**Land To The East Of Stratfield Brake And West Of Oxford Parkway Railway Station  
Oxford Road Kidlington**

**Reference Number: 24/00539/F**

**Note Bene**

Figure 4.7 - Landscape Site Wide GA Plan

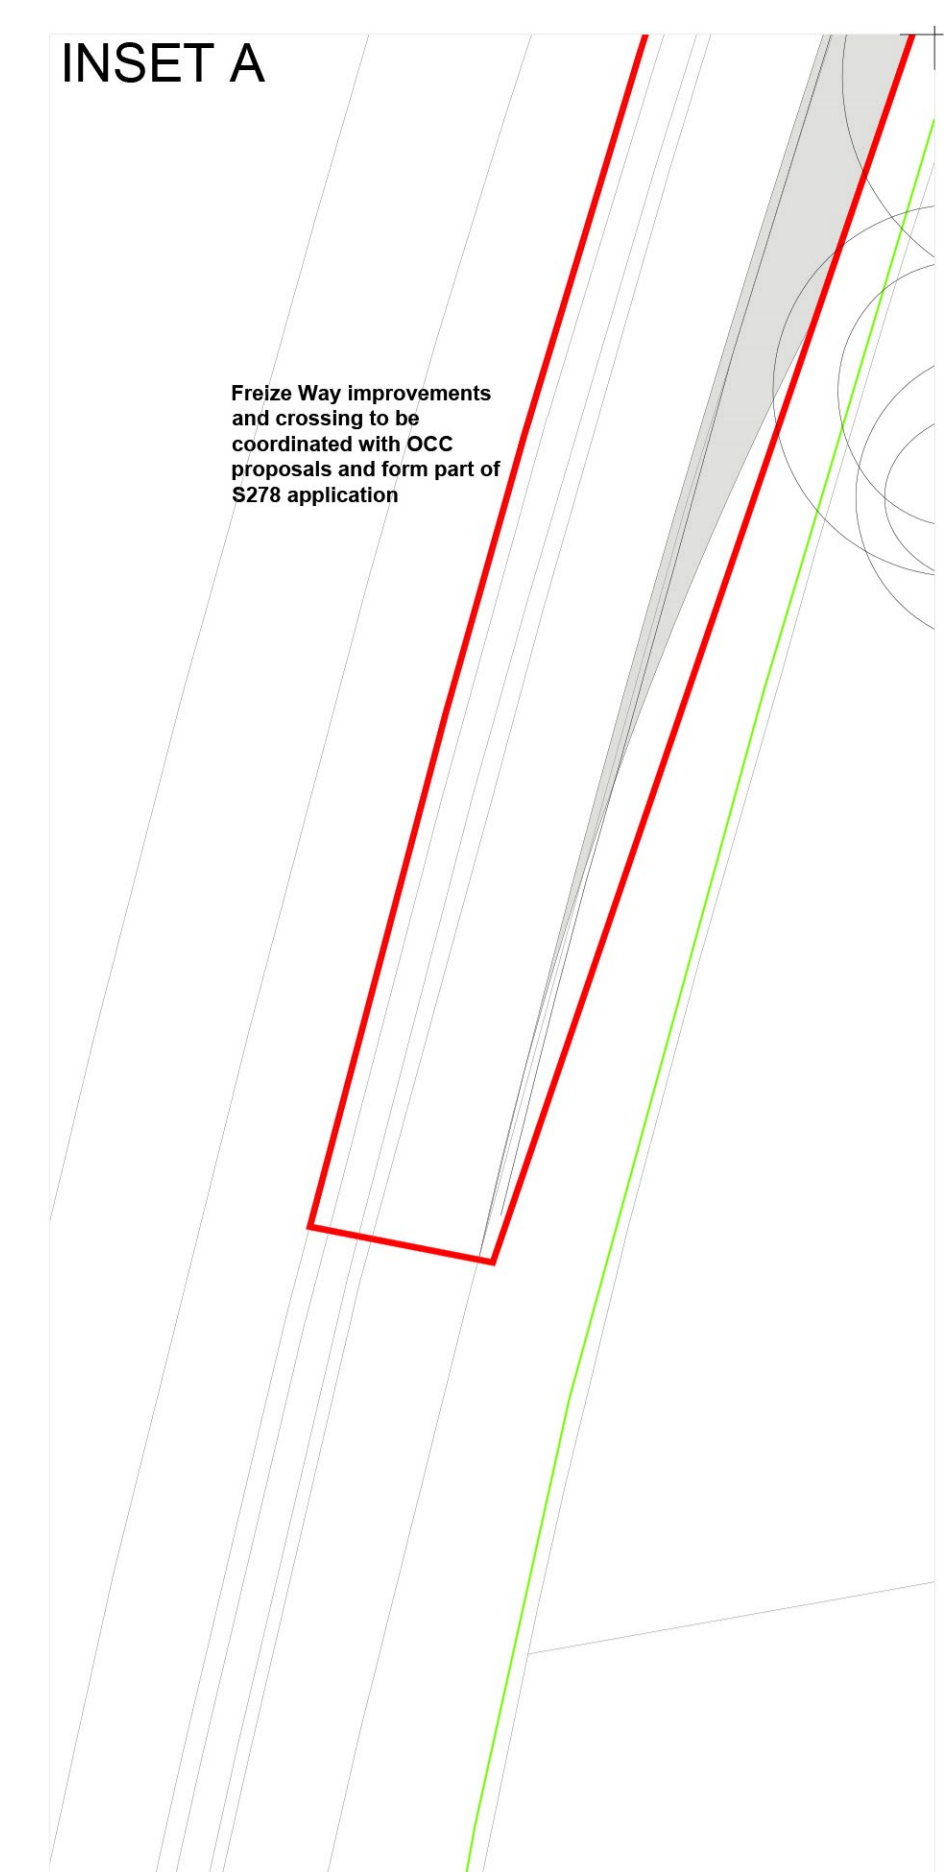
The line of these existing power cables is not shown in "ES Volume 2 4.7 Landscape site with wide GA plan.pdf", however "SS with associated parking" ("SS I take to mean Sub Station) is shown close to the eastern boundary, and it is under the approximate line of a high voltage cable so there is consistency there. The cables are shown on the "Appendix H Site walkover technical note.pdf" but greyed out and not referenced – surely quite a significant omission) nor are the associated pylons – there are 4 on the site that I have identified on Google Earth. Is this significant? Whilst the lines do not actually impinge on the Stadium Building, they could be in the way of construction or maintenance plant, will they need to be re-routed?

On "ES Volume 2 4.7 Landscape site with wide GA plan.pdf" there are a number of trees proposed ("14 - Proposed Tree Planting (below extra heavy standard size, 62 in total") - this planting may not be feasible under or in close proximity to the power lines.

There are other trees shown that are not apparent on Google Earth or the September 2023 Streetview image, on the roadside verge small triangle outside the Stratfield Brake Sports Ground turn off the Frieze Way, that may be prejudiced by their proximity to these pylons and cables (15 on the Legend, "Proposed Trees, 30cm girth and above, 81 in total).
